**Washington State
Department of Transportation**

September 24, 2014

Subject: SP-14-00003 – Sullivan Short Plat
SR 906, milepost 1.03 left

We have reviewed the proposed short plat and have the following comments.

DATE: 08/2014  
 JOB NO.: 14085  
 SHEET 1 OF 2

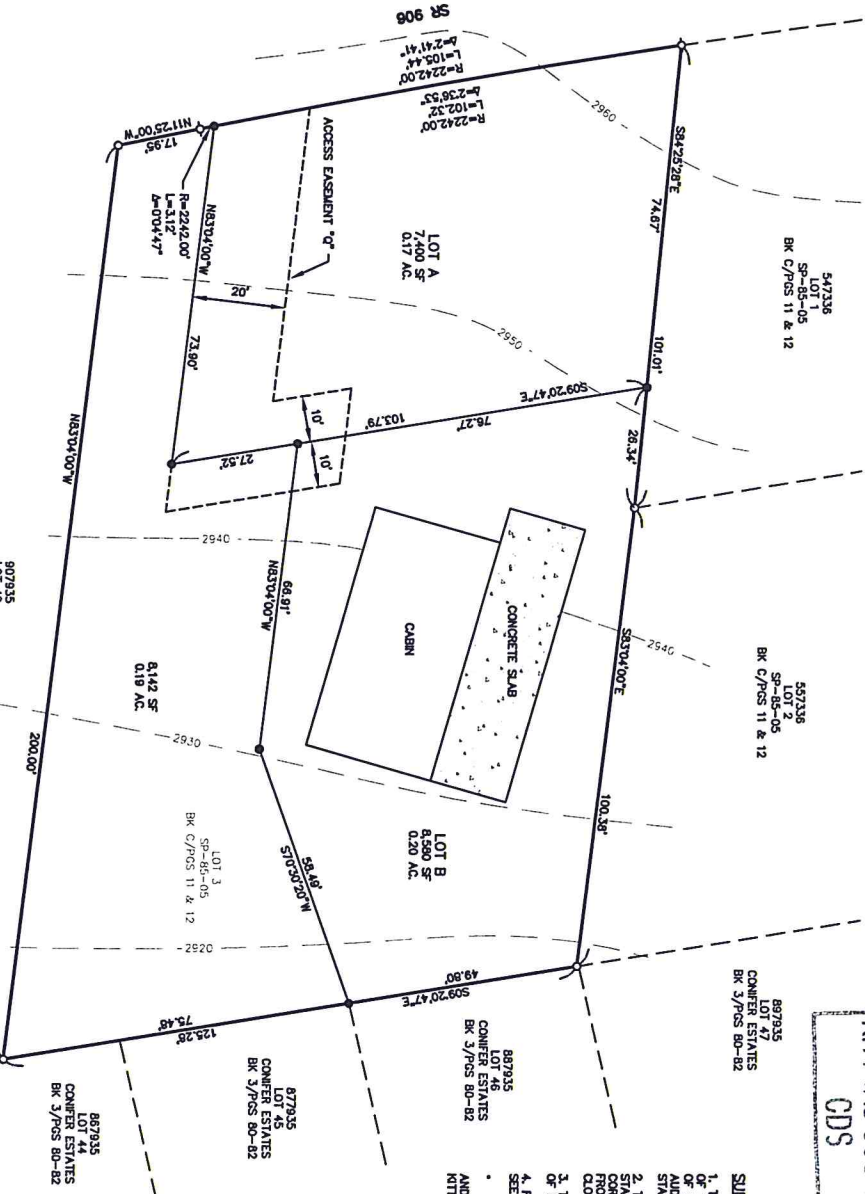
- The subject property is adjacent to State Route 906 (SR 906), a Class 4 managed access highway with a posted speed limit of 35 miles per hour. The subject property is permitted (permit #2725) to have an approach at milepost 0.99 left; however, it appears this approach has been relocated further to the south (milepost 1.03 left). The property owner is required to contact Mark Kaiser of the WSDOT – South Central Region Office at (509) 577-1668 to update the permit.
- Snow storage is an ongoing issue with WSDOT. Any snow accumulated on these properties shall not be moved onto WSDOT rights-of-way. We encourage the proponent and future residents to not underestimate the potential for large volumes of snow and designate a snow storage area on the property.
- Parking will not be permitted within WSDOT rights-of-way.
